RE: Master Drainage Report for Westpoint 40
Drainage Master Plan
Stamp Date: 10/10/17
Hydrology File: K09D041

Based upon the information provided in your submittal received 11/09/17, the Drainage Master Plan **is not** approved for Work Order. The following comments need to be addressed for approval of the above referenced project:

MATCH LINE – SEE SHEET 1

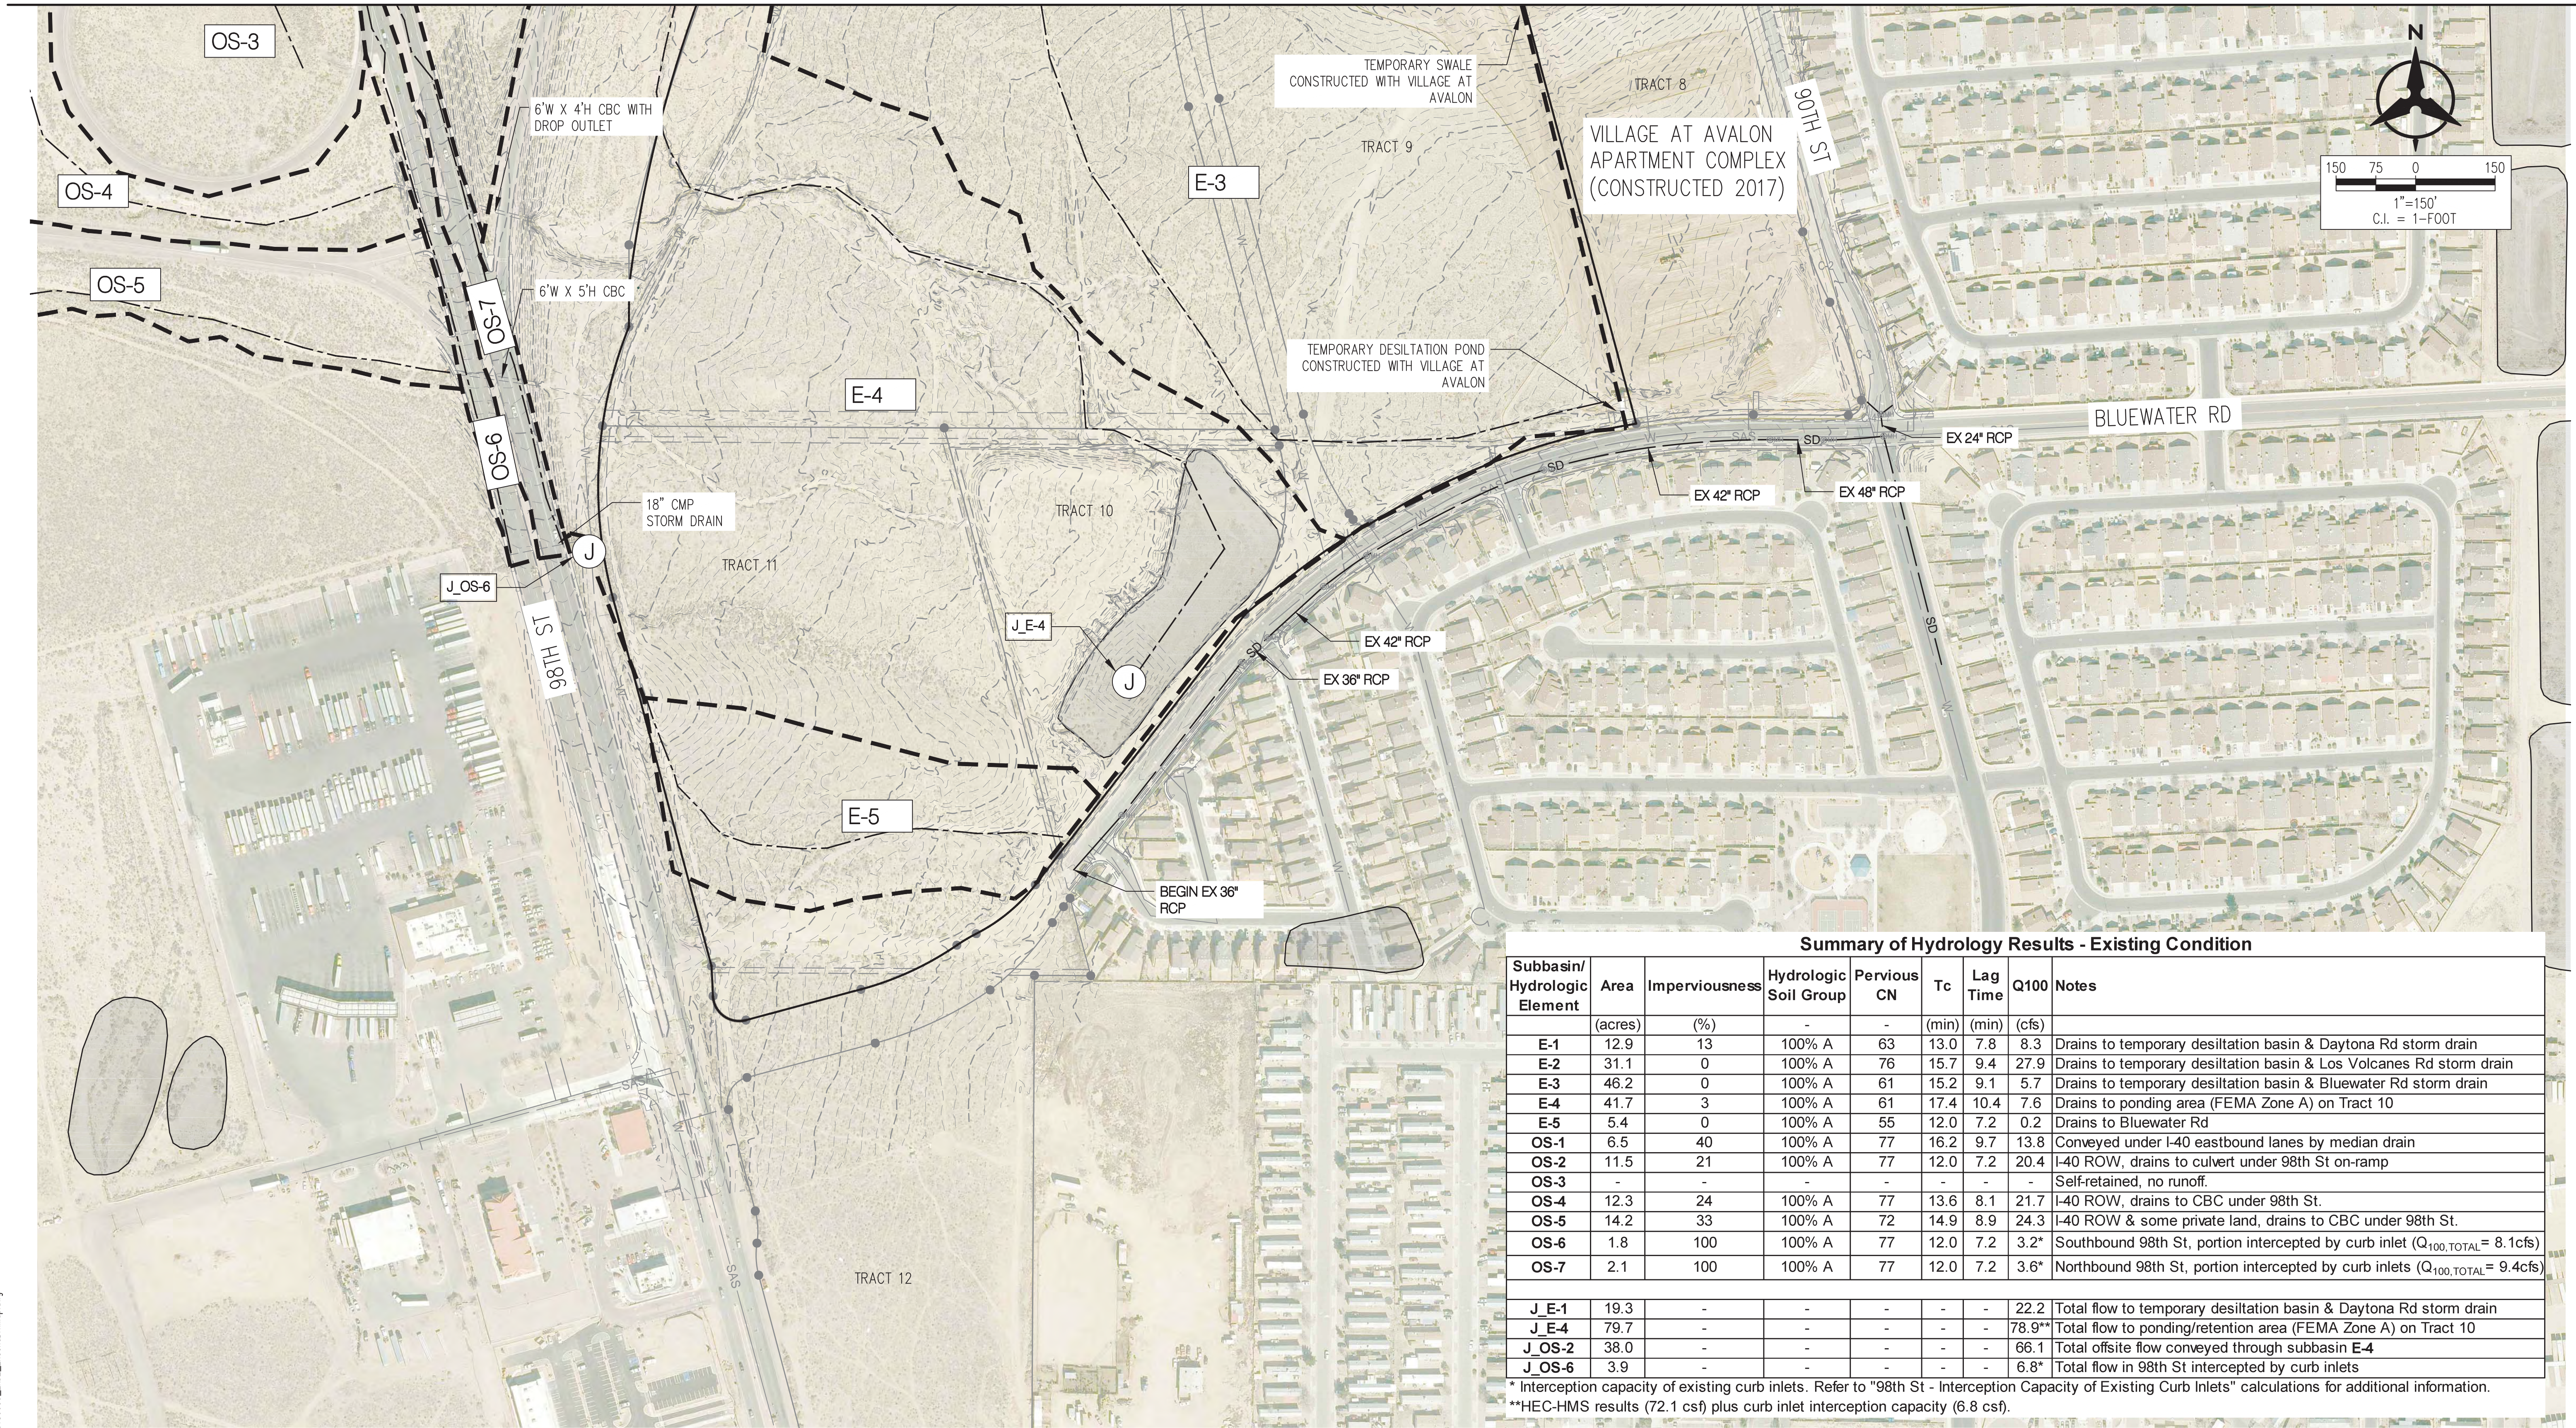
3. On Exhibit 2 - Sheet 2 of 2, please label the existing storm sewer on 90th St. just south of Blue Water as an existing 54" RCP.
4. On Exhibit 3 – Sheet 2 of 4, please add a note that a spillway will be provide from the detention pond to Daytona Rd within the proposed drainage easement. Also add this wordage about the spillway in the drainage report Section V. Developed Conditions B.2 Option A.

CHECKED BY: VCS PROJECT NO. 20180059 SHEET NO. 3 OF 4

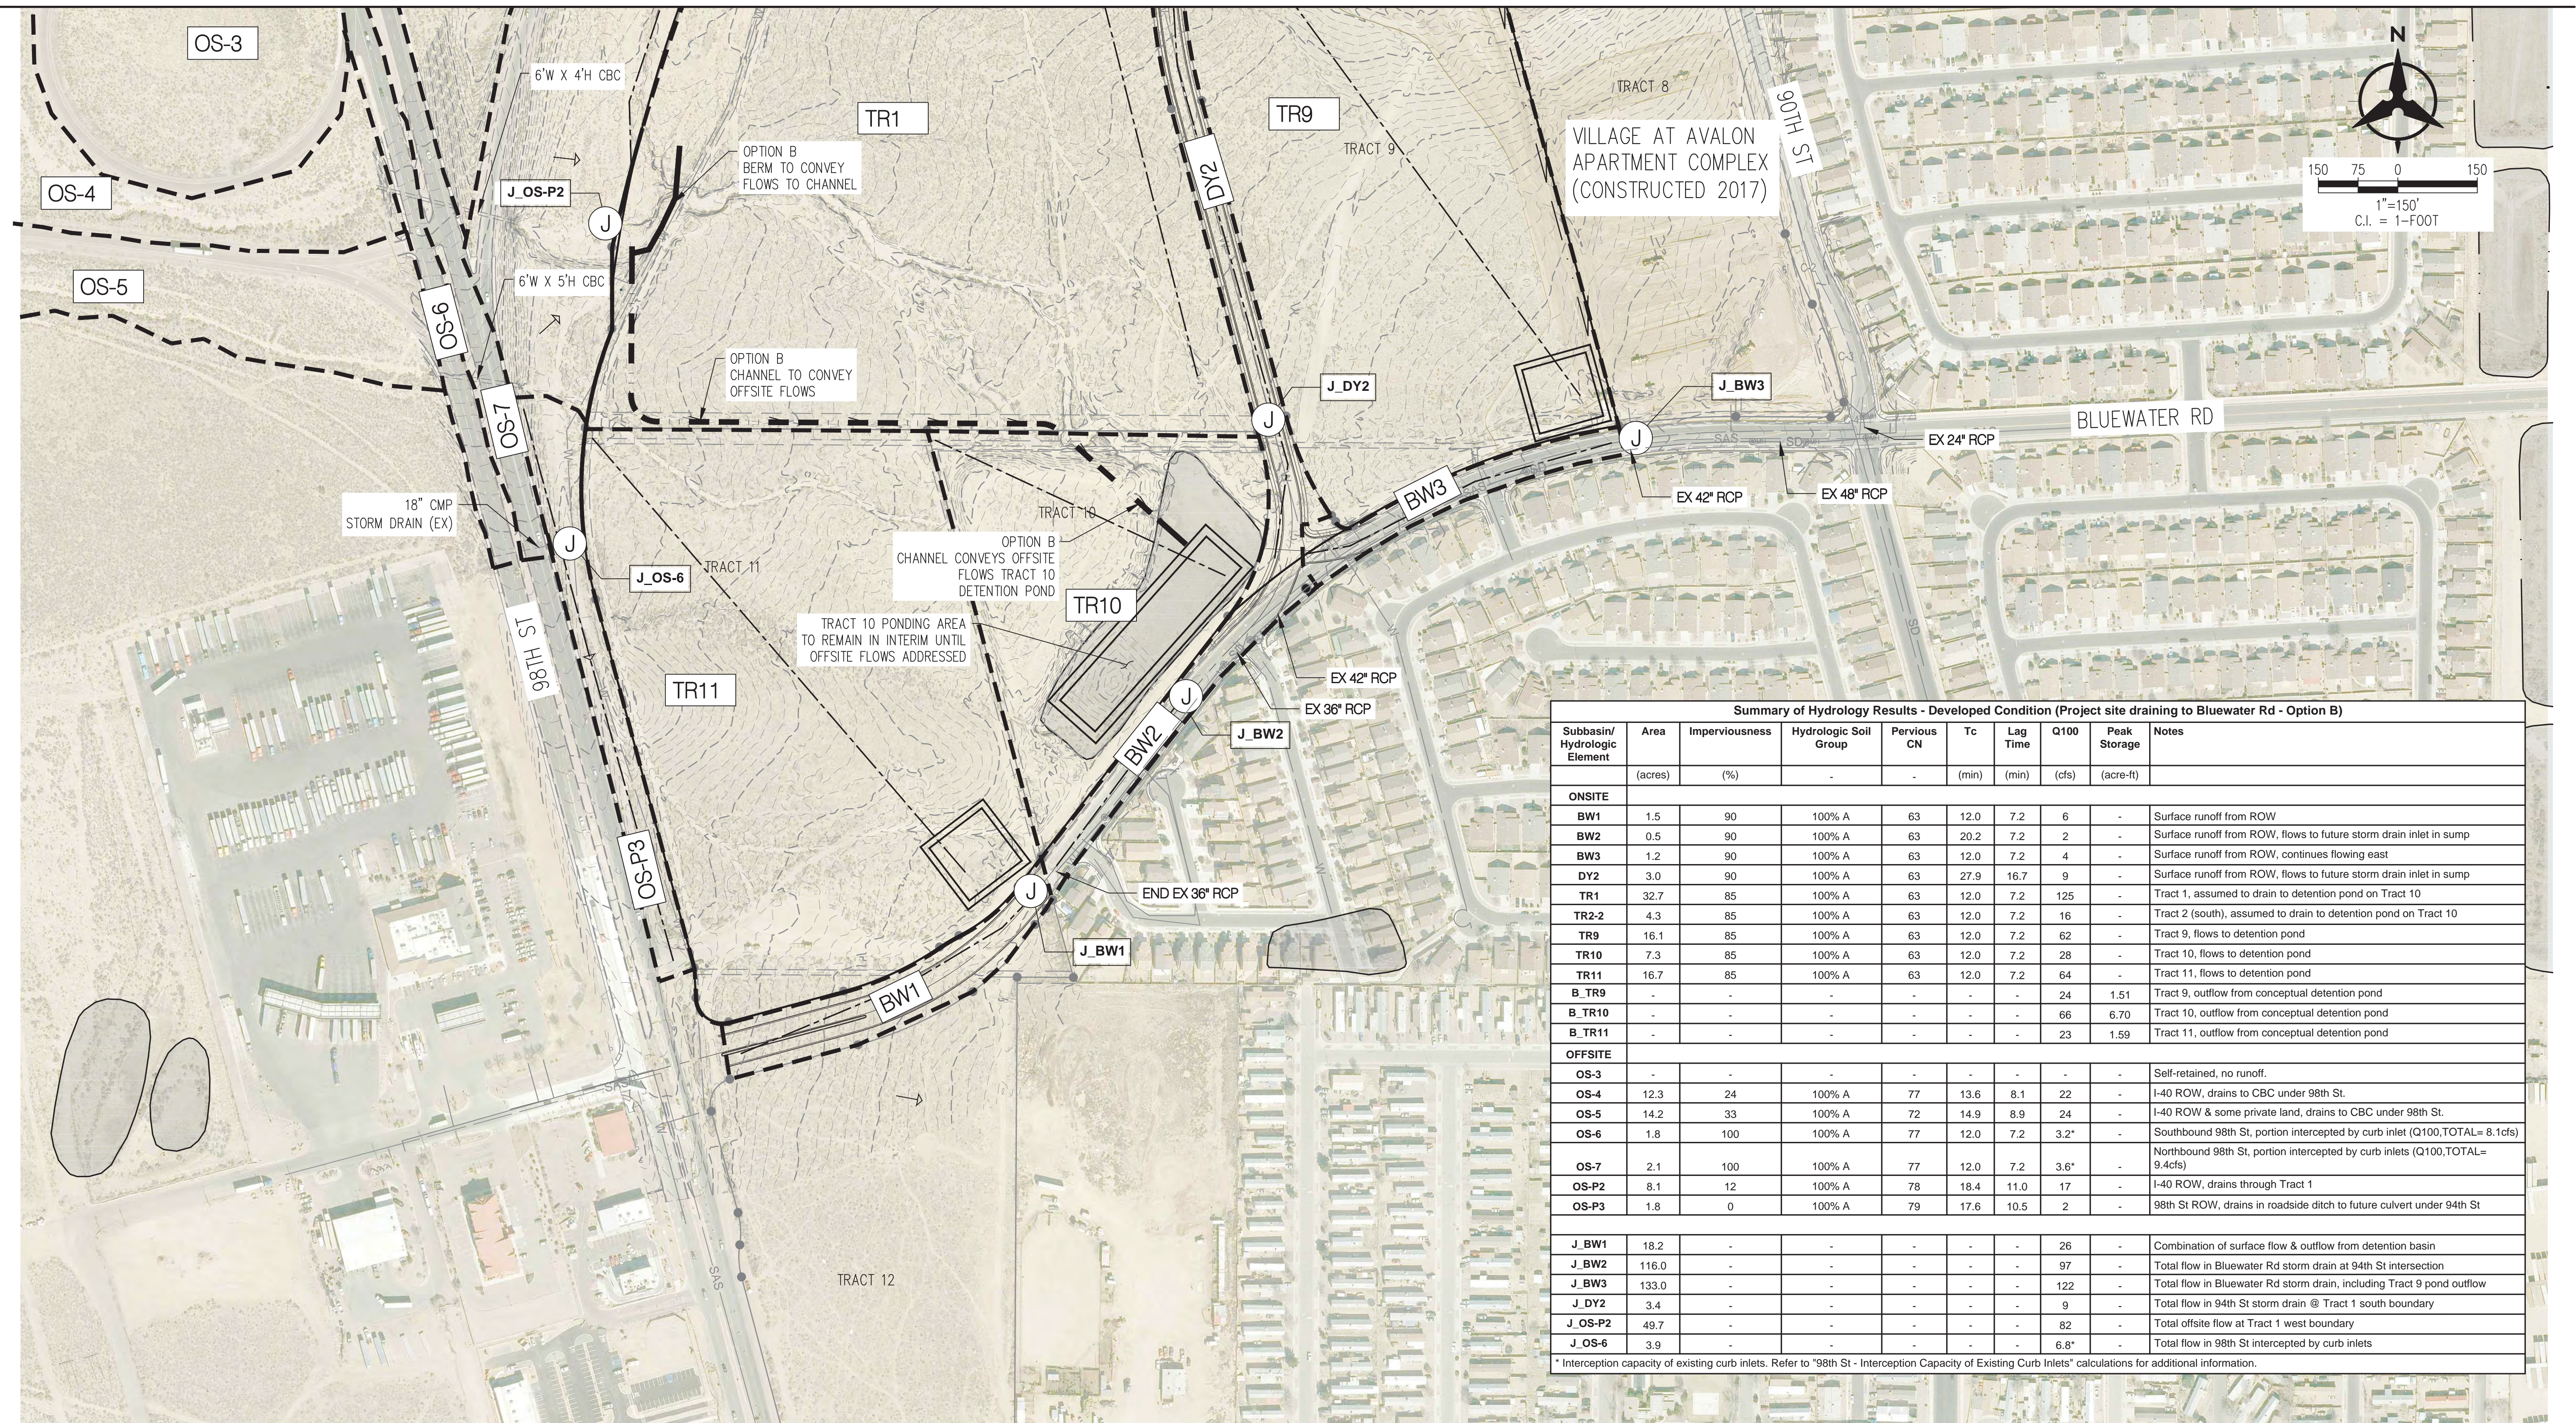
5. On Exhibit 3 – Sheet 3 of 4, please add a drainage easement on the entire dike since it is carrying public storm water.
6. On Exhibit 3 – Sheet 4 of 4, please add a drainage easement on the entire dike since it is carrying public storm water.
